Registration Identification Number: 20049691

I am pleased to submit a Written Representation to the A46 Bypass scheme.

Elevation 1
1 : 100

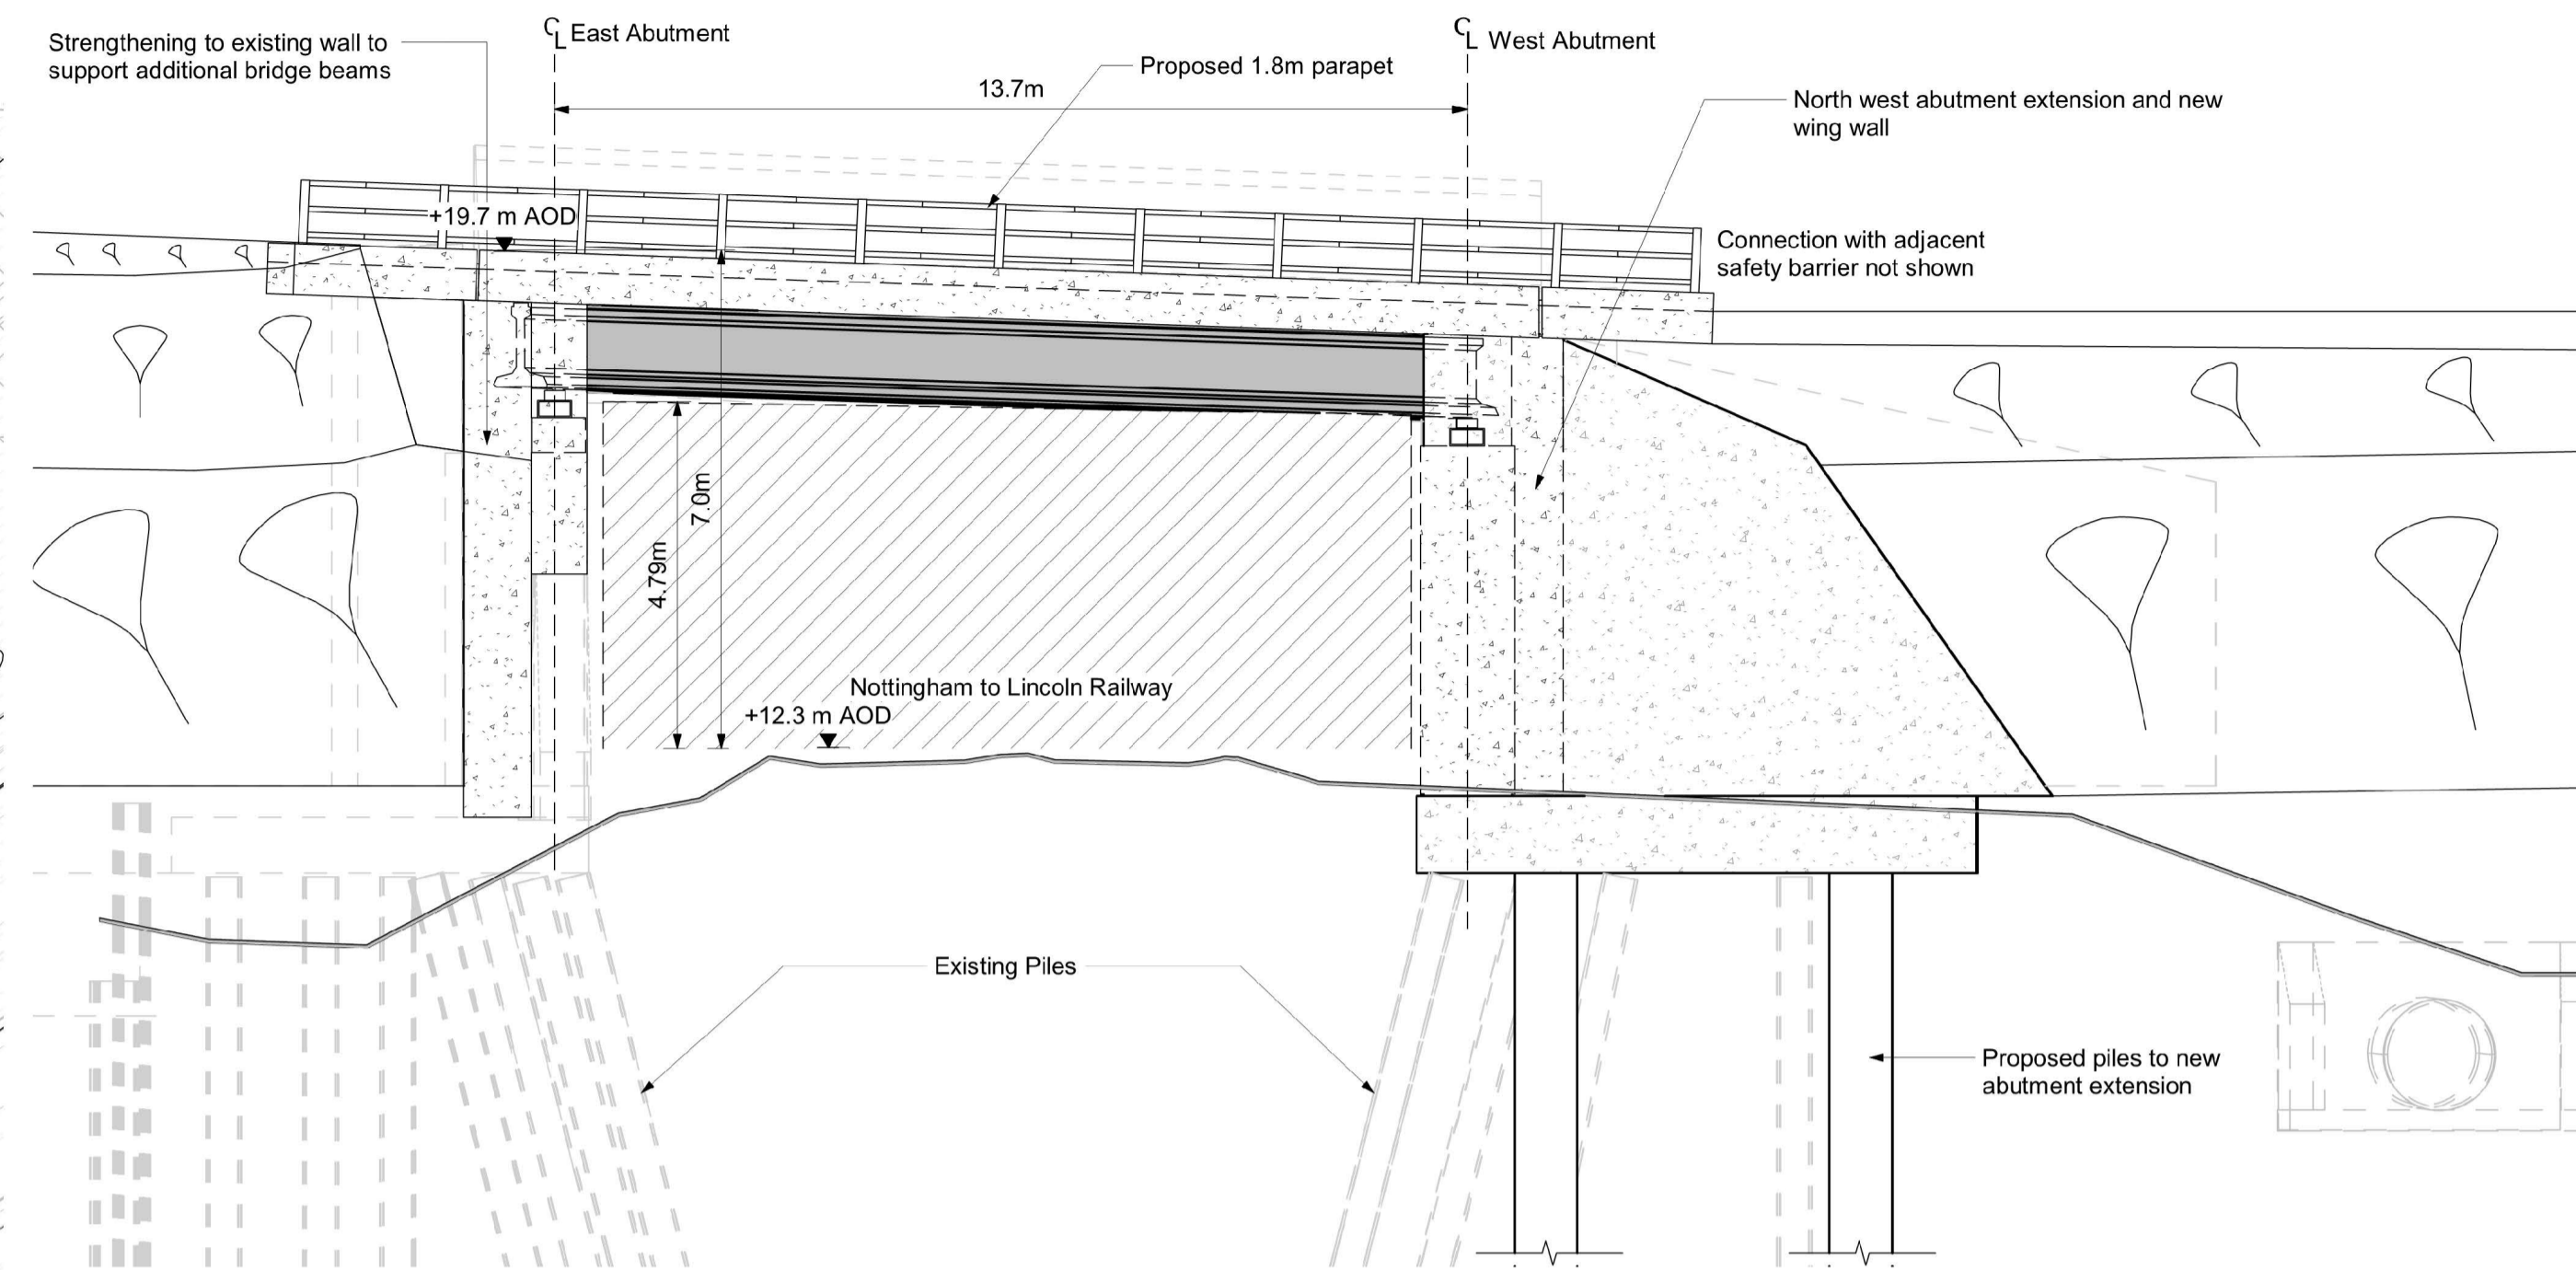
The existing rail height A.O.D. beneath the A46 East overline railway bridge on NOB1 is given as 12.3m in Elevation 1 in the D.C.O. submission documents.

- a rail height of 12.3m A.O.D.;
- a maximum rail to soffit height of 4.79m: &
- a rail to road surface height of 7m.

This gives a construction depth of 2.21m.

It also gives an additional headroom of only 0.01m over the desirable minimum soffit height of 4.780m for the standard structure gauge.

In effect the D.C.O. Elevation 1 shows the soffit height at the new widened northern side of the bridge and the Jacobs 2016 Report shows the soffit height at the original southern side of the bridge. The difference in soffit height might be explained by the co-planar arrangement of carriageways due to the super-elevation of the road.

Thus there appears to be some incompleteness in the basic information supplied in the D.C.O. documents and also in the Atkins 2022 report with regard to the A46 East bridge over the railway.

The provision of a General Arrangement drawing of the complete bridge with the headroom and soffit heights at the existing side and the widened side shown would answer these concerns.

Elevation 3 - Proposed North Elevation
1 : 200

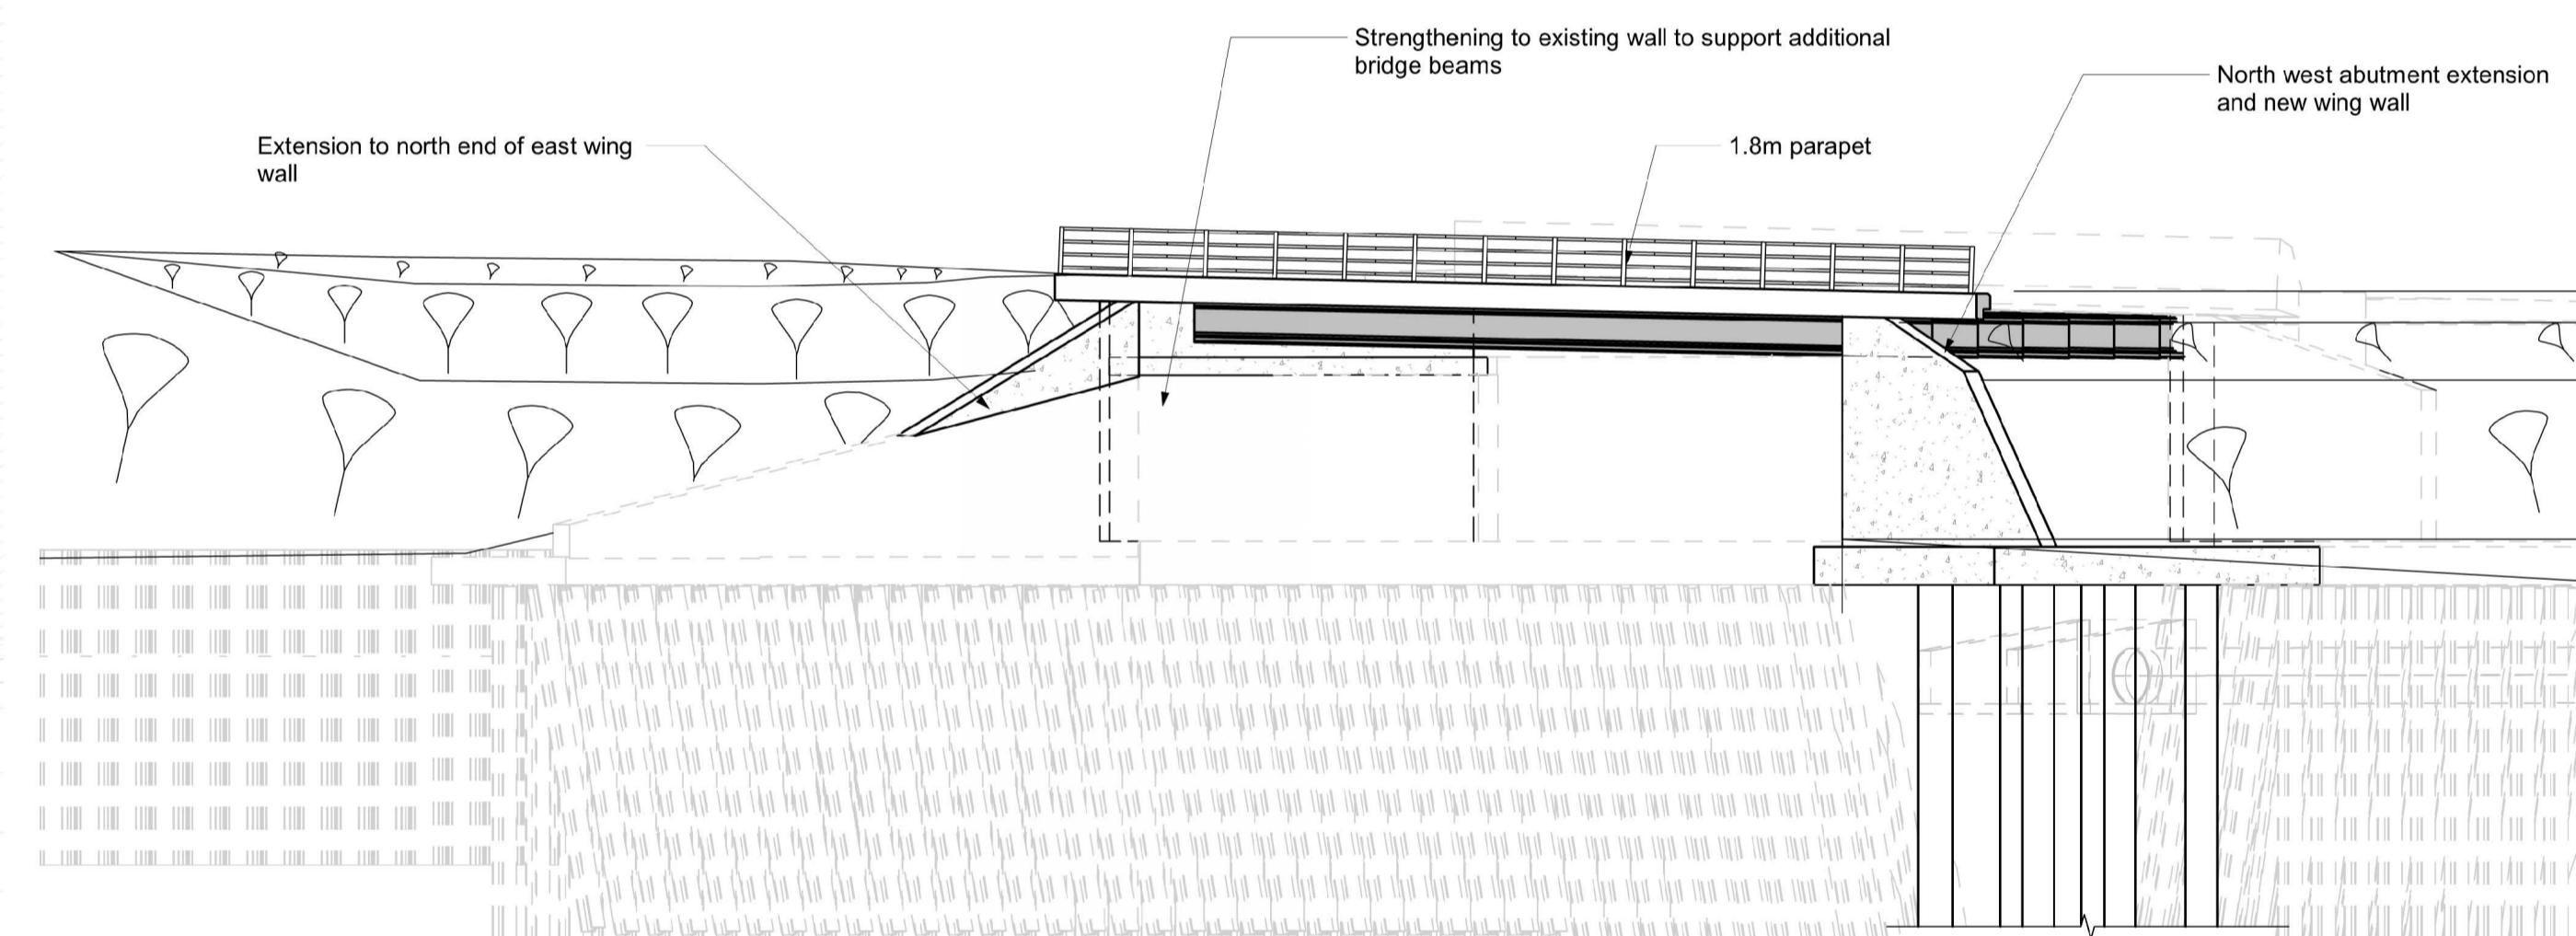
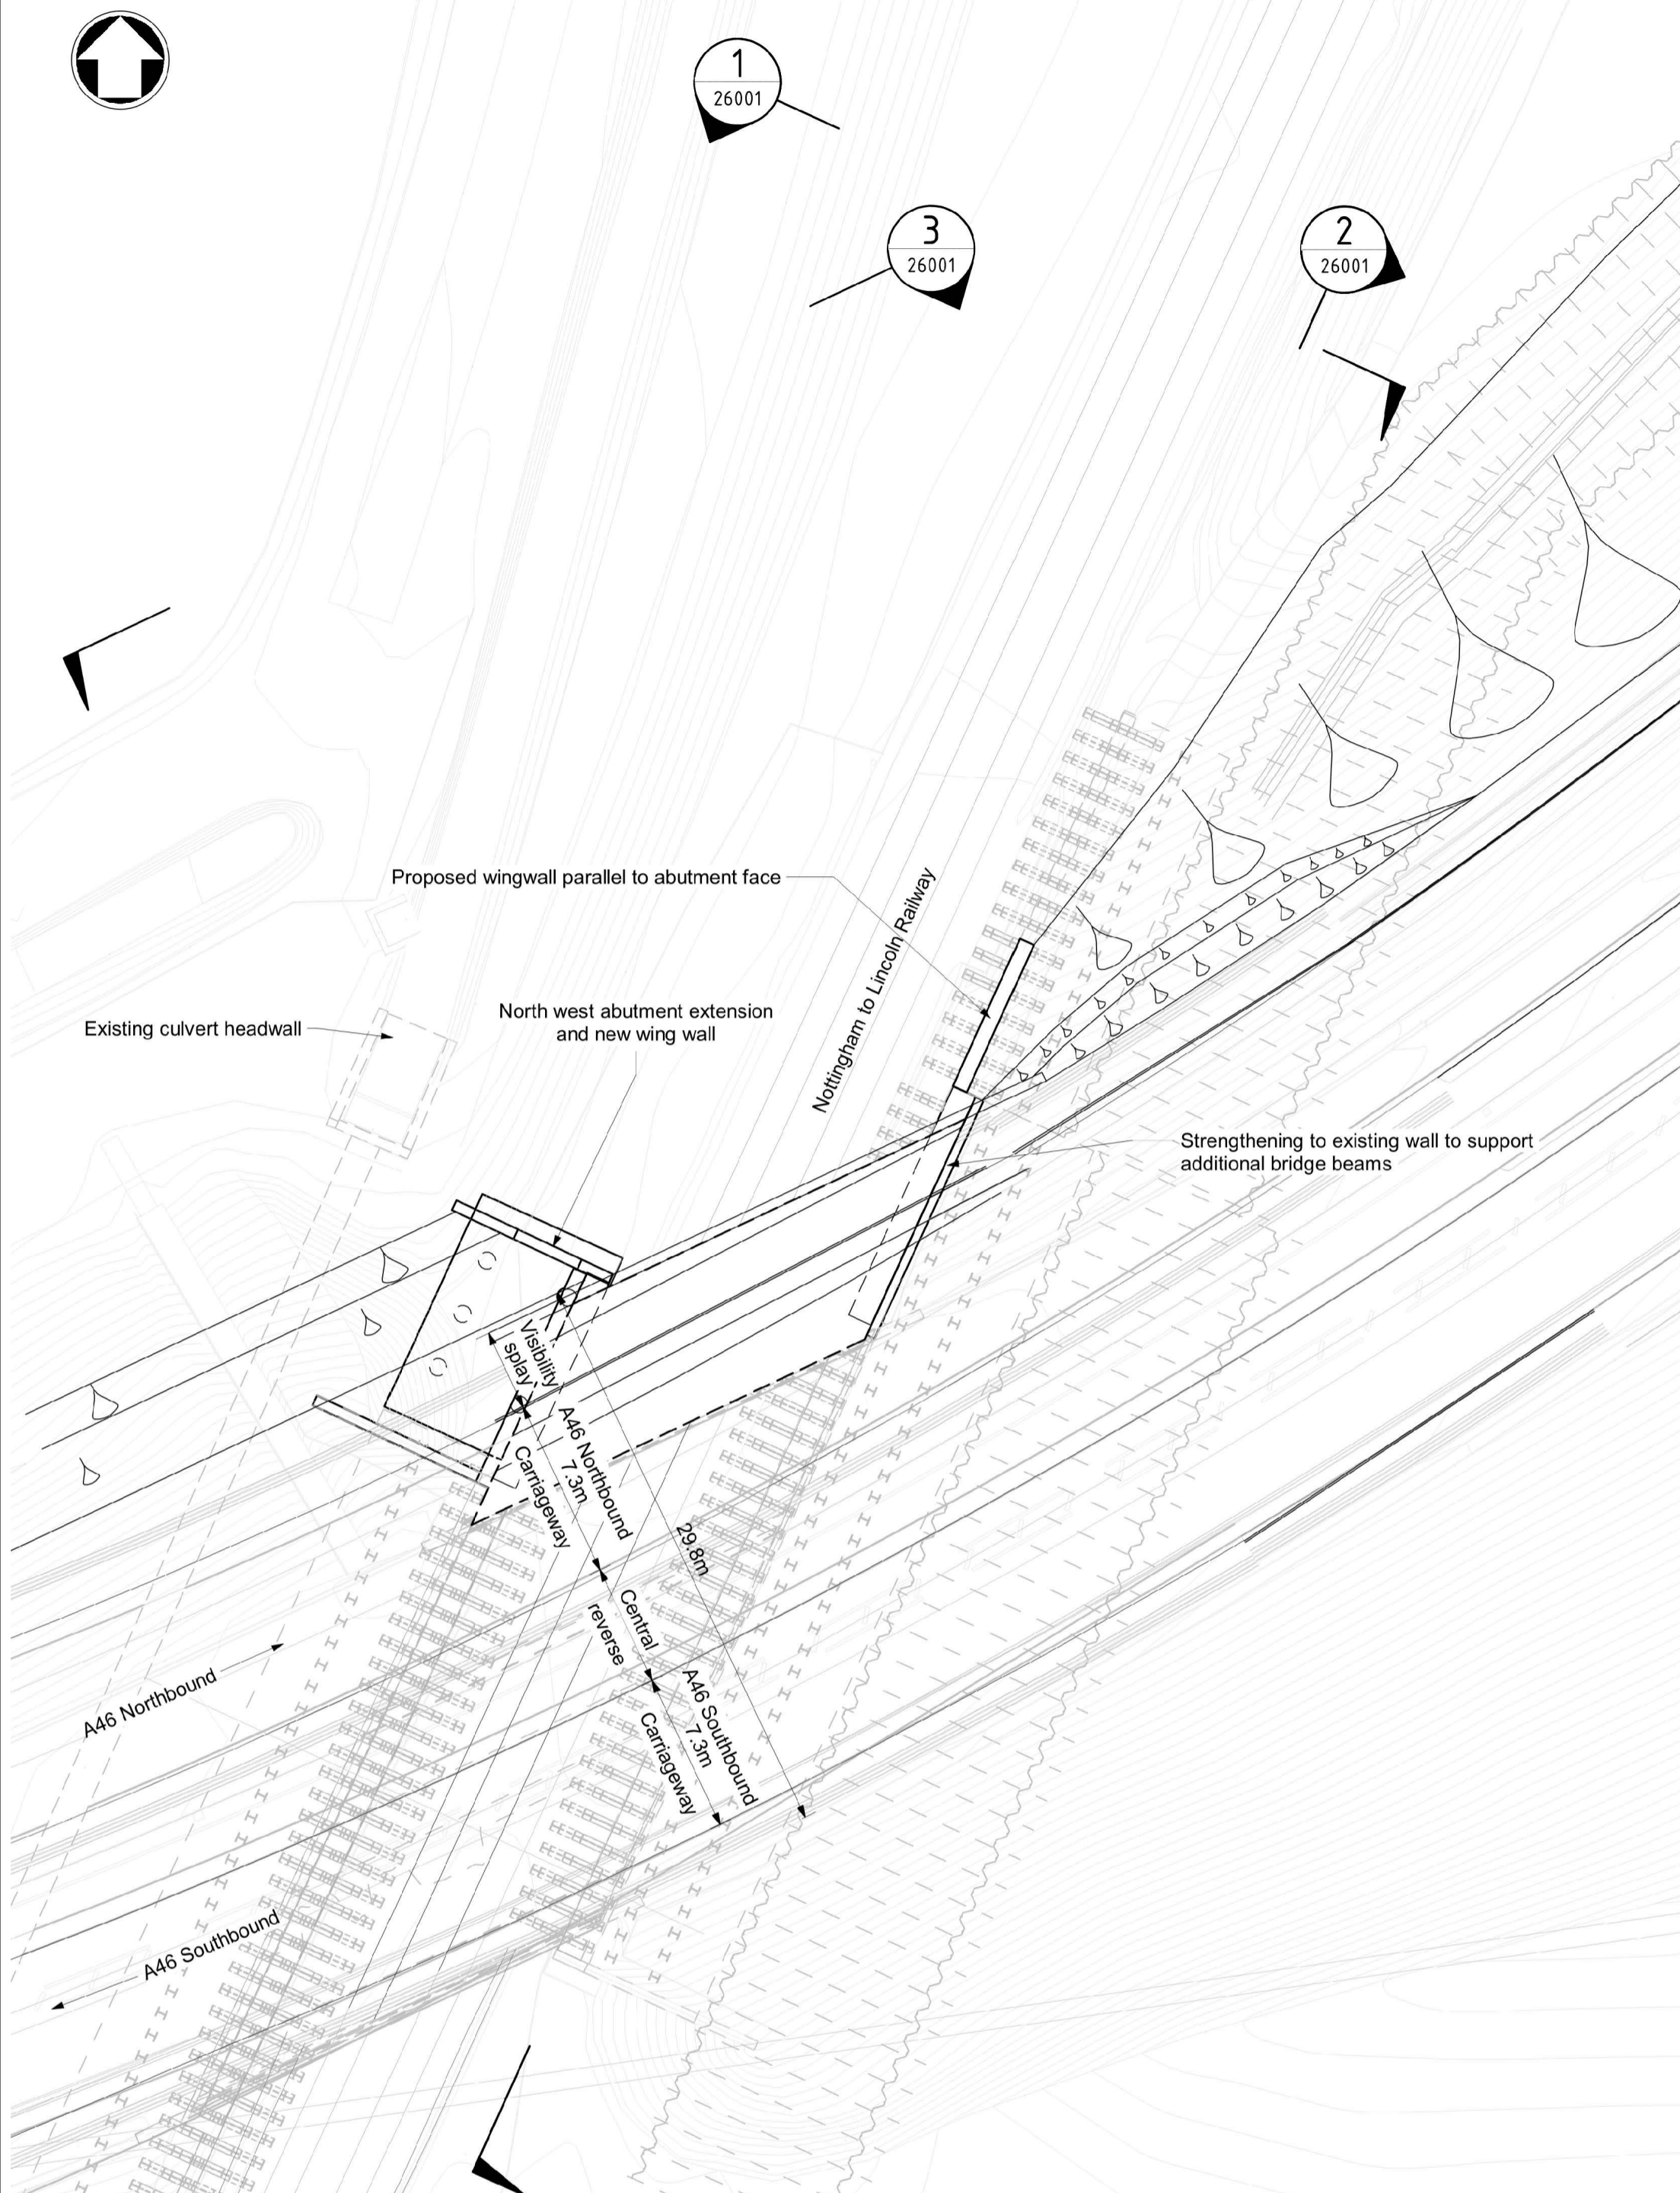
The arrangements on the cross-sections H & I above do not seem to co-incide with the plan view shown on the D.C.O. and the Applicant’s response that both seem to imply a co-planar arrangement of the new soffit with the old soffit rather than staggered separate carriageway soffits.

The concern here is that the additional bridge span in a co-planar arrangement lowers the effective soffit height when the need is to raise the soffit height to allow the railway grade to commence as early as possible on the exit from the original bridge.

Also in the D.C.O. documents is Elevation 1 showing the additional span:
